Subject: FW: FP/246/21/PL - Kitchen Extract - 26 Felpham Road, Felpham, West Sussex

Reference: FP/246/21/PL - Kitchen Extract in Felpham, West Sussex

SOUTH ELEVATION

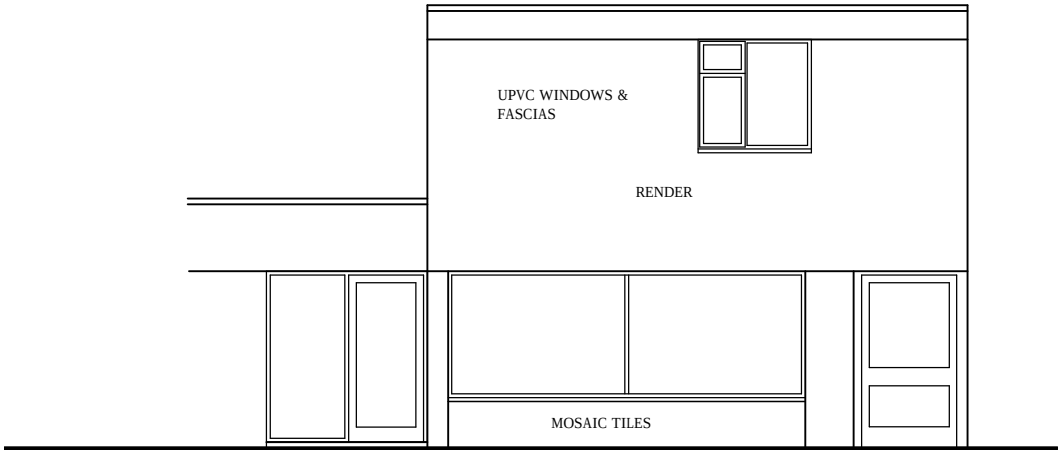
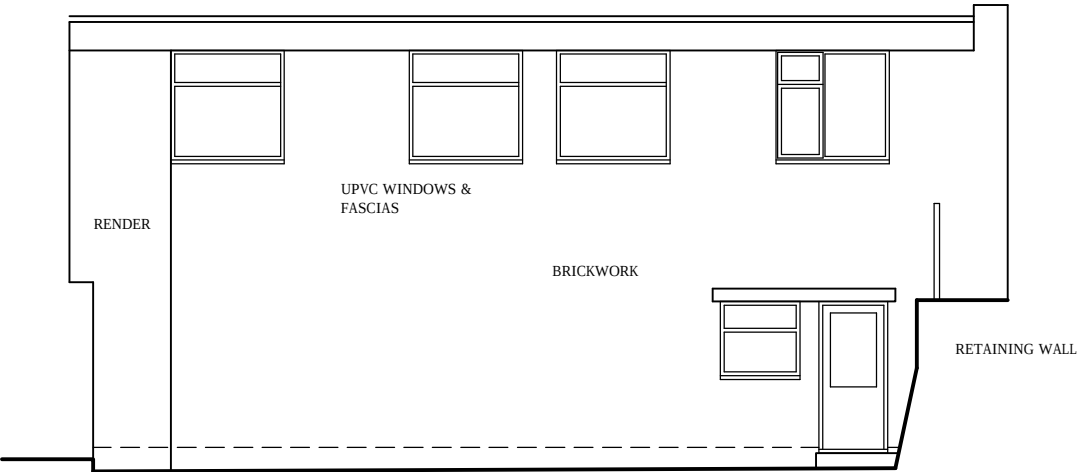
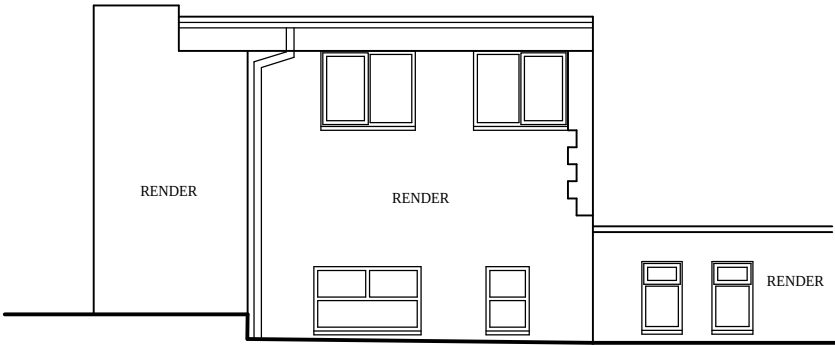
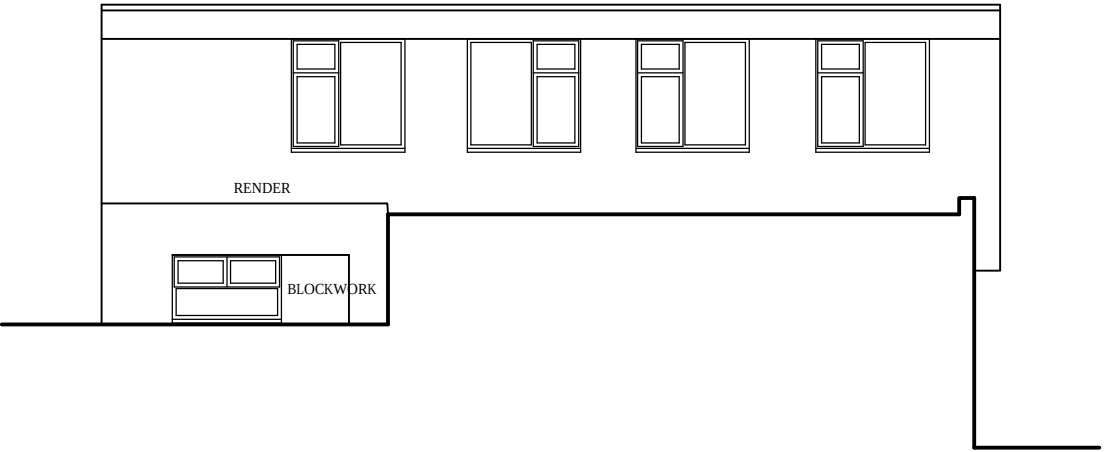
I am slightly confused as to where the flue is going as it is shown on the both the South and North elevations. The West elevation implies that it is on the South side.

- Are the tenants in the garden at the back or with windows open, going to have the smell of cooking all day and into the night?
- Could fumes be emitted via the flue that are dangerous to people's health? Some of the tenant's have severe health issues
